RE: 4346 E. Mercer Way, Critical Area Determination (CAO17-003)

Please find attached an updated Critical Area Study and Watercourse and Wetland Buffer Reduction Report for CAO17-003 submitted on March 8, 2017. The updated report has addressed the recommendations by the City of Mercer Island's ESA Peer Review Memorandum dated June 20, 2017.

SHEET
3 OF 5

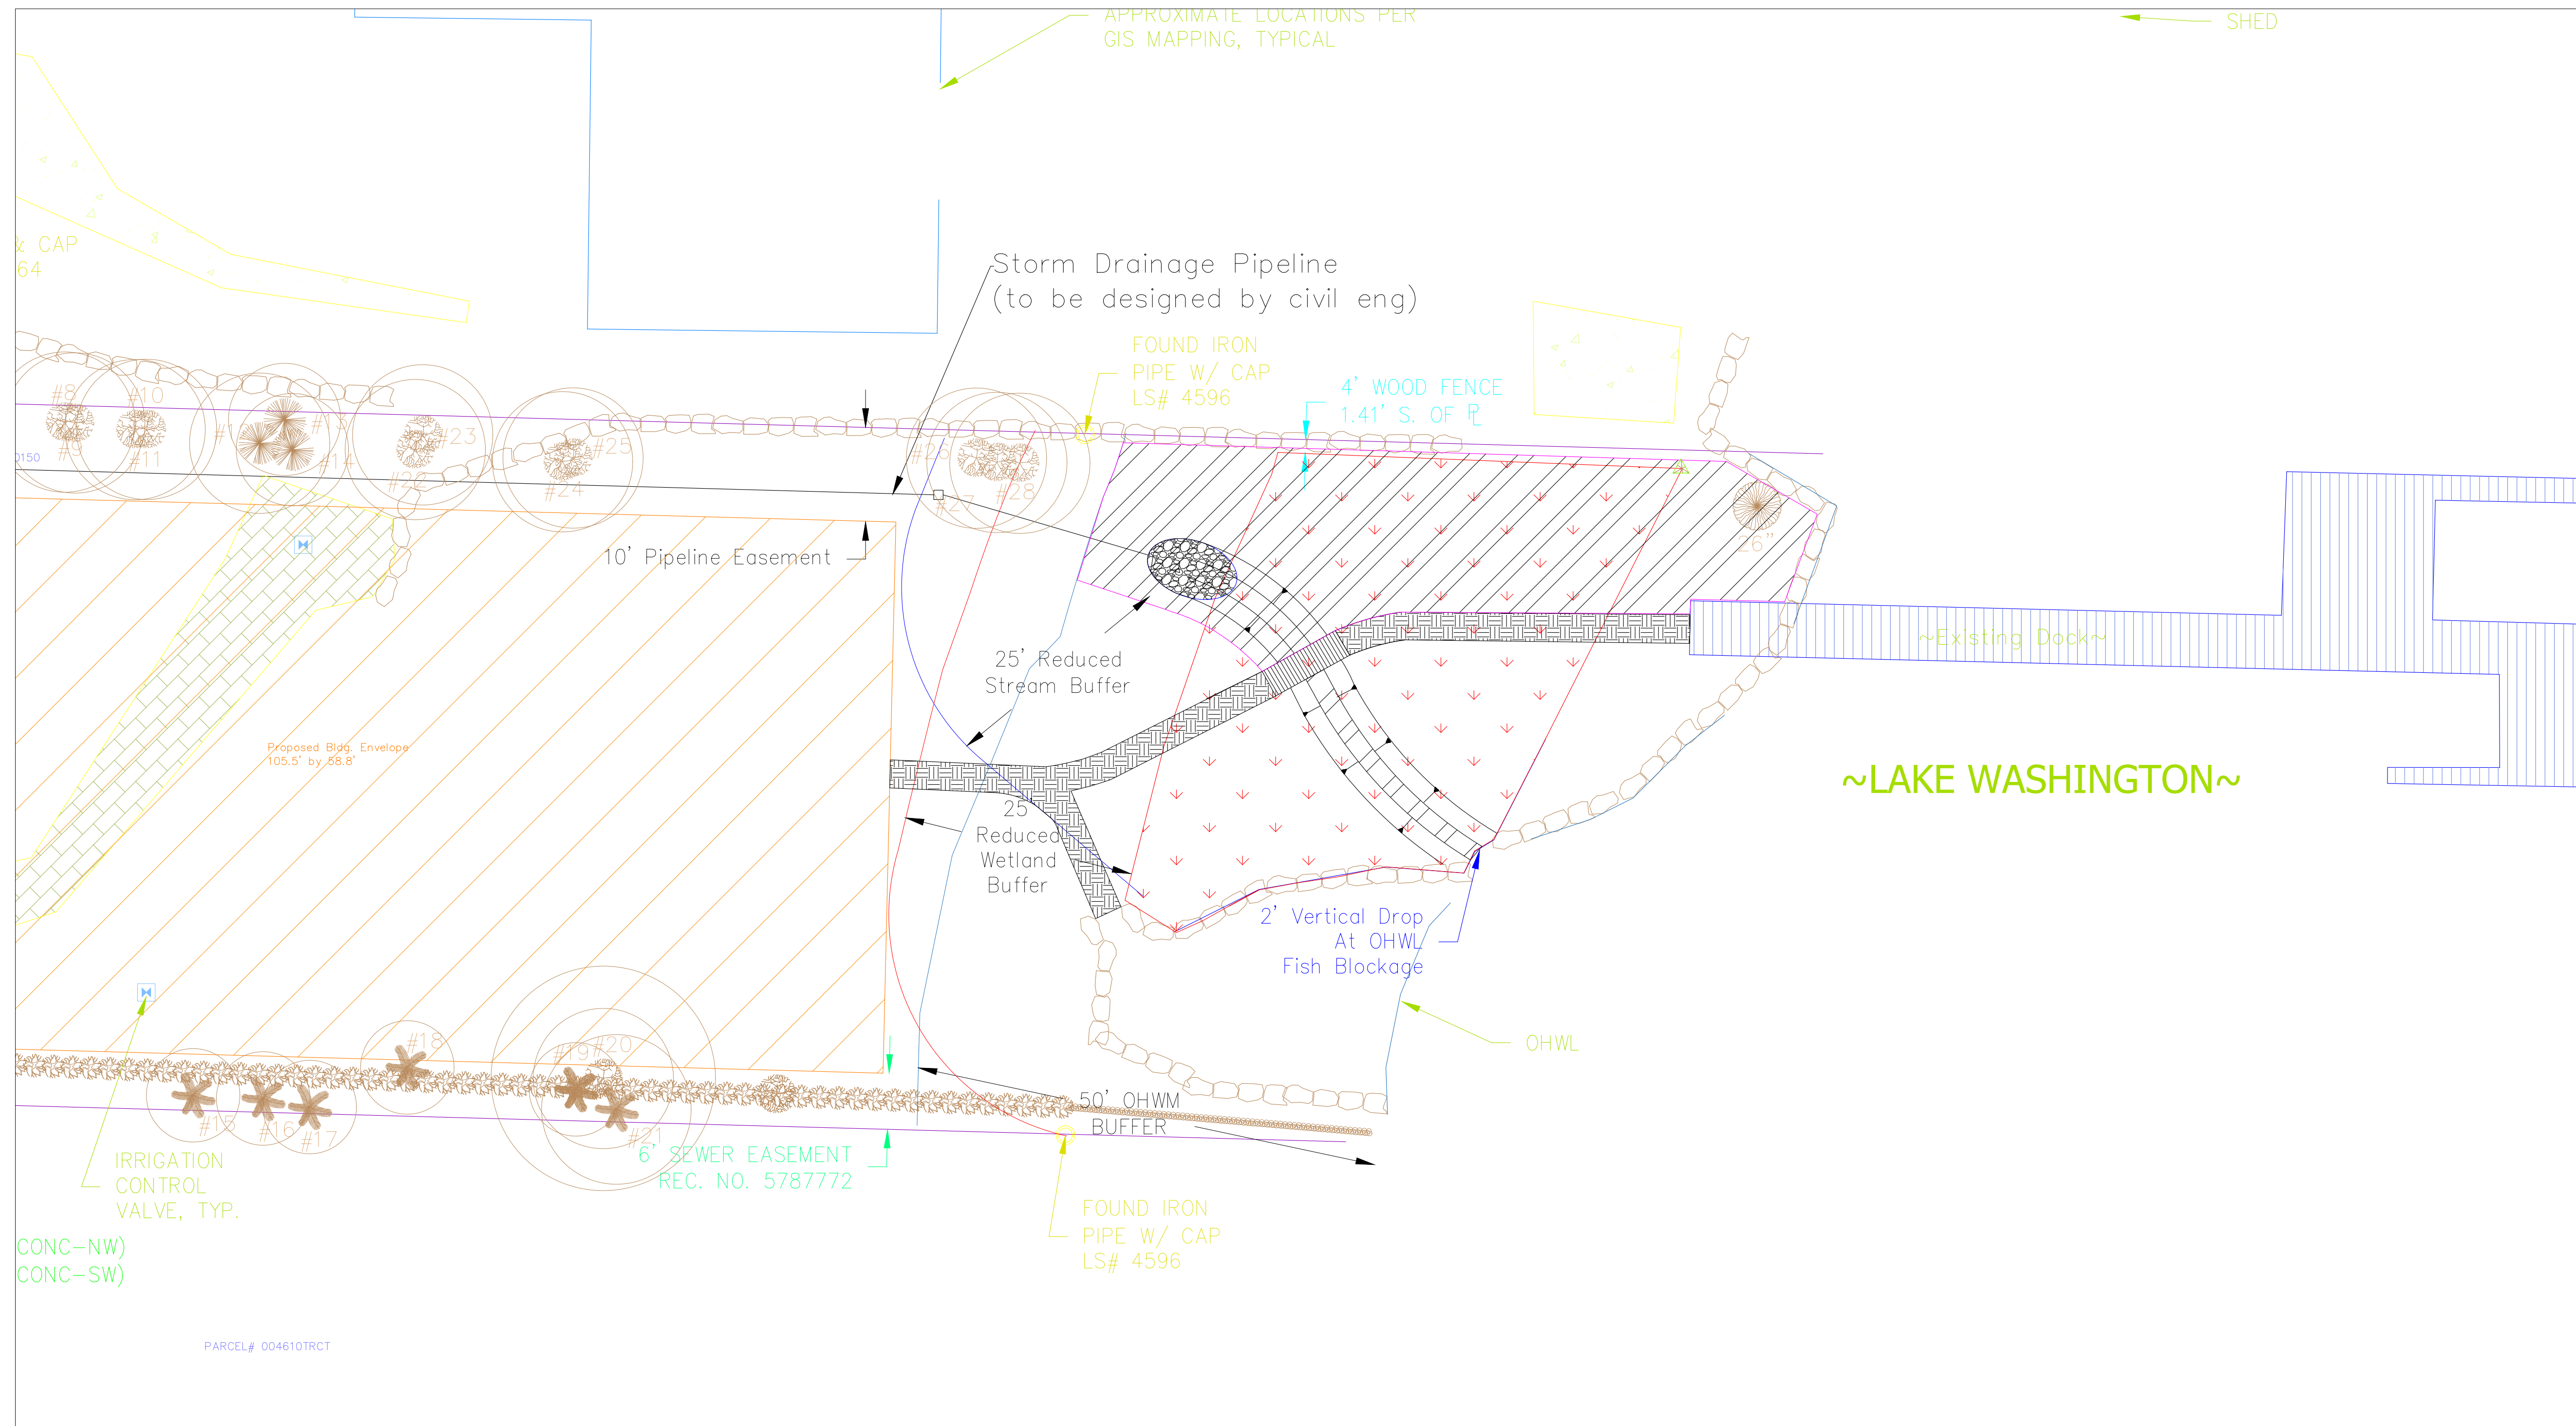
4	Update Mitigation Plan to include open Type 2 sections	Revised study includes an updated buffer enhancement and mitigation plan for the open Type 2 sections. The updated buffer enhancement is for a total of 4,816 square feet (up from 1,056 square feet, a four-fold increase). Mitigation planting is proposed at a 1.46:1 ratio for a total of 1,900 square feet to compensate for buffer alterations. Additional mitigation implementation is being proposed to include removal of on-site permanent coal fired brick/stone/steel BBQ within the buffer, removal of patio within the buffer and implementation of woody debris and logs along the watercourse.
5	To not place daylighted watercourse into culvert or to relocate any of the onsite watercourse segments	All references and proposals to place daylighted watercourse back into culvert has been removed. All proposals to relocate any of the watercourse segments have been removed. This has resulted in a 40% smaller development envelope.
